**Consultation Response from KC,
Highways Development Management****2021/93614 adj, 101, Allen Croft, Birkenshaw, BD11 2AB****Erection of two dwellings****Date Responded: 23-11-
2021****Responding Officer: Mark
Berry****Responding Ref: 8-11NE-1**

This application seeks approval to the erection of two 3 bedroomed semi-detached dwellings at land adjacent to 101, Allen Croft, Birkenshaw.

PROPOSED SITE PLAN 1:500

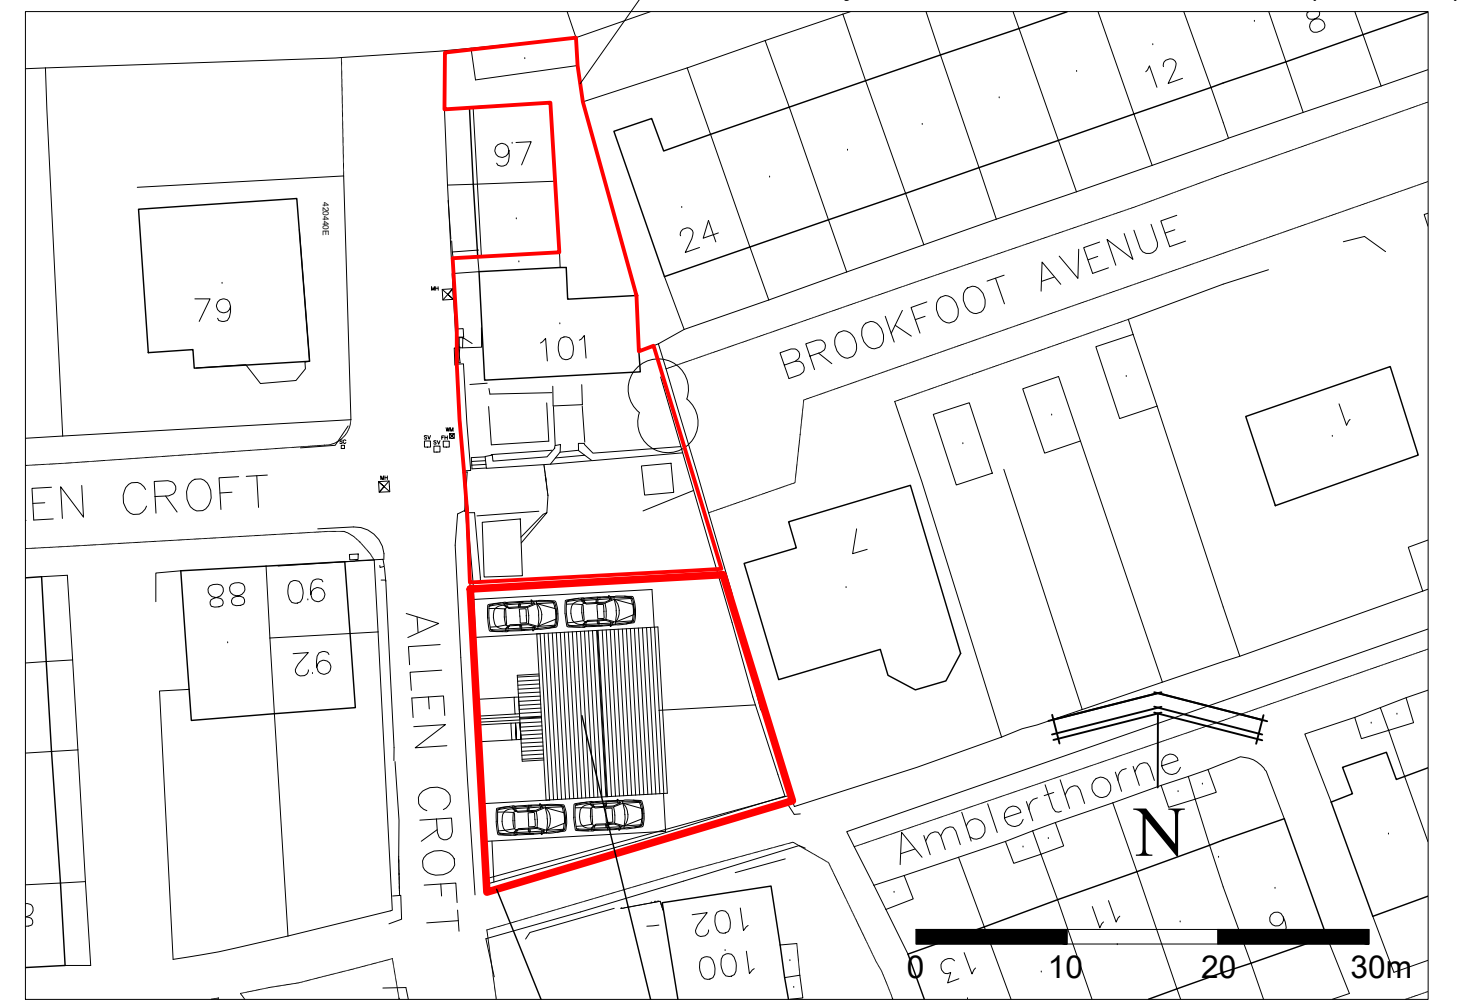
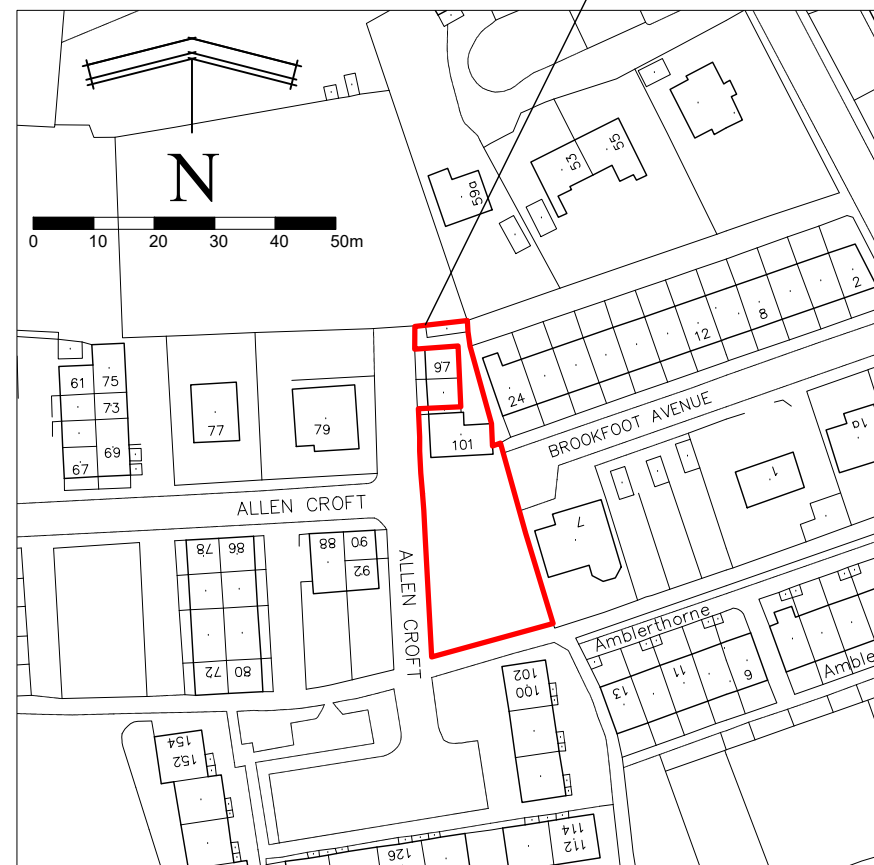
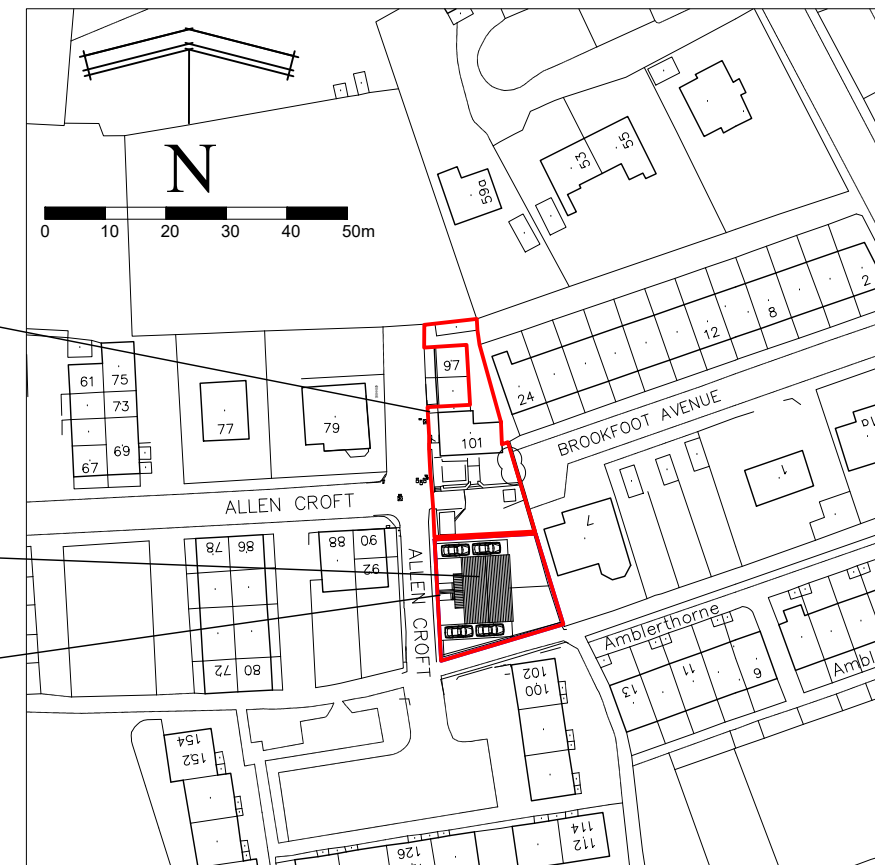
1, The plans should be amended to show that nothing shall be permitted to be planted or erected within a strip of land 2.0m deep measured from the carriageway edge of Allen Croft along the full frontage of the site which exceeds 1.0m in height above the level of the adjoining highway. This is to ensure adequate visibility in the interests of highway safety.

2, Bin collection points should be provided to both dwellings to enable bins to be presented on collection day without either obstructing Allen Croft or proposed driveways.
